Able Marine Energy Park

Material Change 2

Applicant's Responses to

Application by Able Humber Ports Ltd for Able Marine Energy Park Material Change 2
The Examining Body's written questions and requests for information (ExQ3)
Issued on 15 February 2022

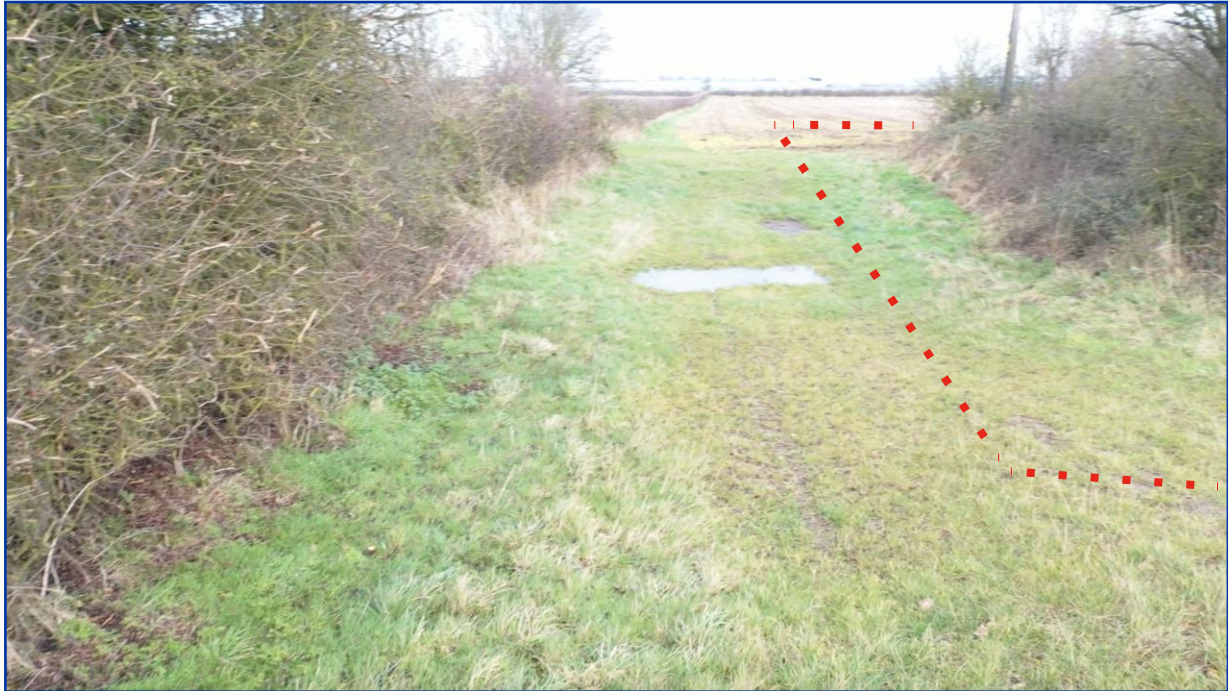
ExQ3	Question to:	Question:	
1.	General and Cross-topic Questions		
Q1.0.1	All	Where up-dated documents are supplied, please supply a tracked as well as a clean version.	Noted.
Q1.0.2	App	Following the ASI of 10 February 2022, please supply copies of the drone photographs/videos relating to location P1.	These were supplied to the Planning Inspectorate by Able (email dated 14/02/22) and BDBP (email dated 17.02.22).
Q1.0.3	App	What height above ground level are the existing lamp standards on the northern part of the AMEP site?	<p>The Applicant confirms that the height above ground level for existing light columns are either 21m or 30m.</p> <p>The Applicant has submitted drawing AME-036-30008 to illustrate where the existing light columns are located, as document reference TR030006/D5/2.</p>
Q1.0.4	ABP	What height above ground level are the ABP silos to the south of the AMEP site?	This question is not addressed to the Applicant.
